Application No: R/60/22/PL
Site Address: The Windmill Inn Mill Lane Rustington BN16 3JN
Description of works: Extension and remodelling of existing public house to form hotel with 20 No bedrooms and associated parking and landscaping. This site is in CIL Zone 4 (Zero Rated) as other development.

Thank you for your internet representation made on 30th March 2022 which has been recorded as an objection with the comments as follows:

Drawing No.	2021-6377-001	Rev.	B
-------------	---------------	------	---

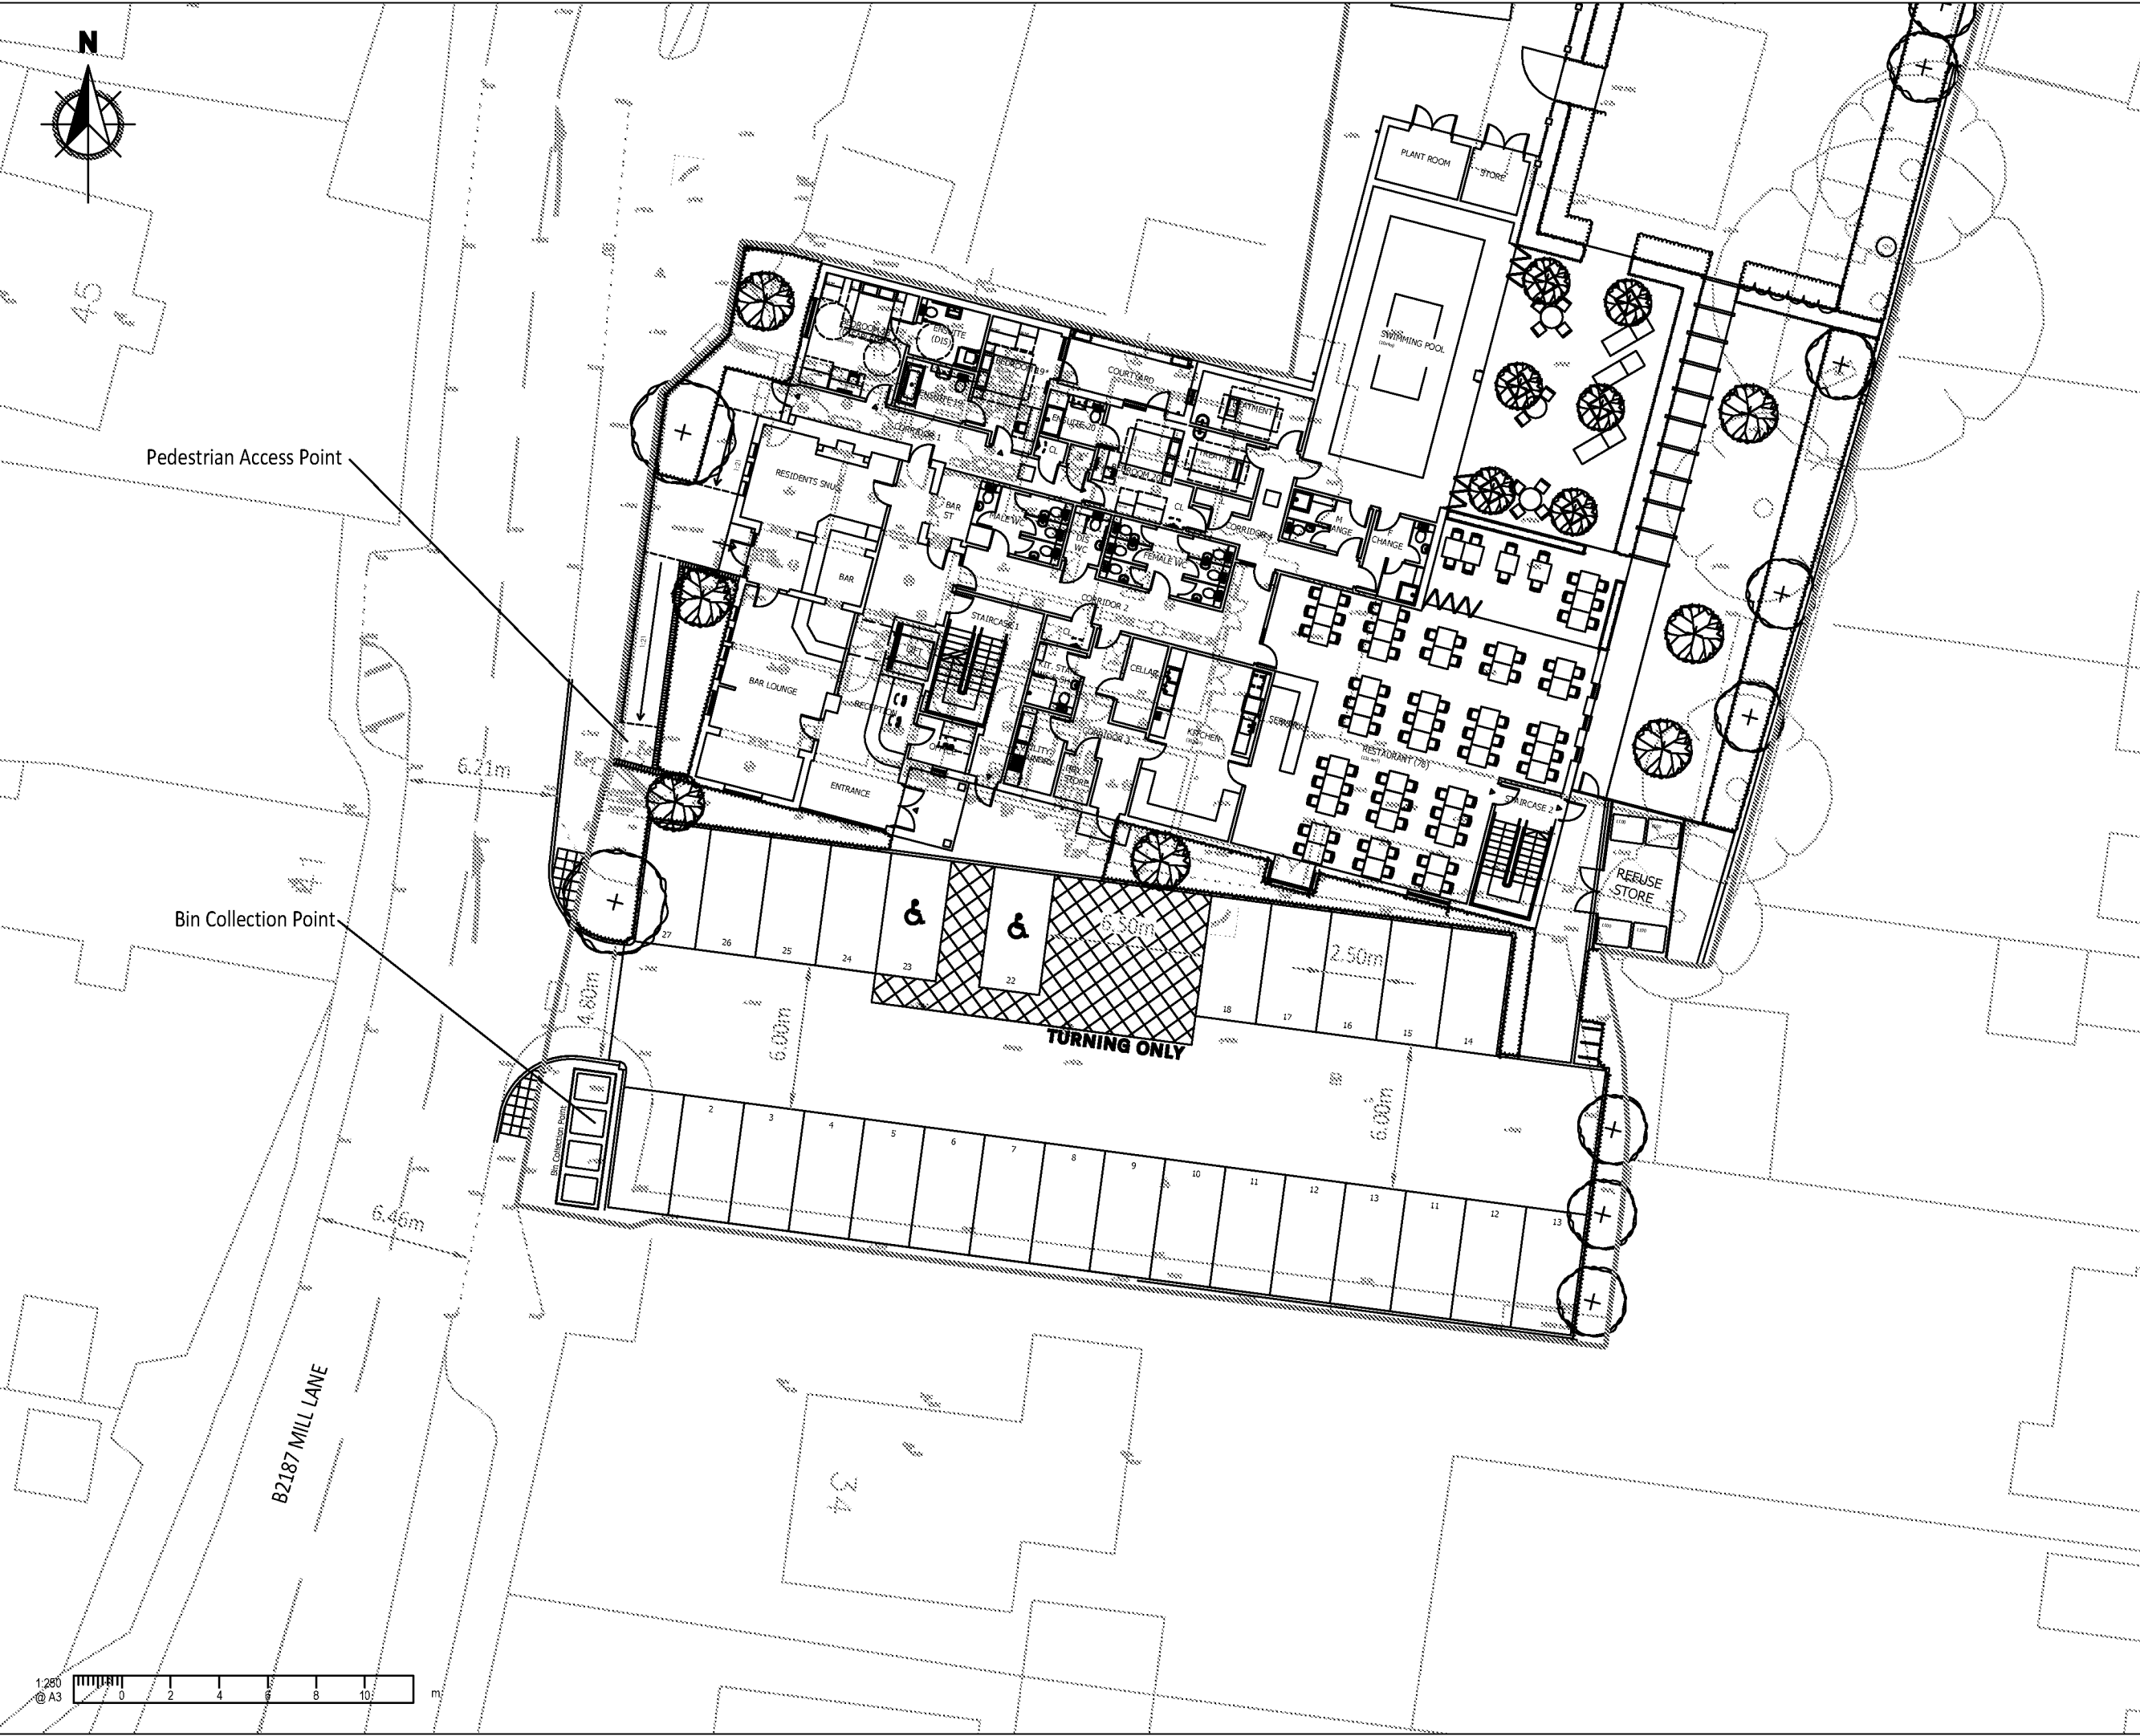
This would cause parking chaos, and cars would spill out down Mill lane where I live. The current car park could never accommodate 20 plus cars plus staff cars, even with remodelling. Mill lane is unadopted and very narrow with no extra parking available.
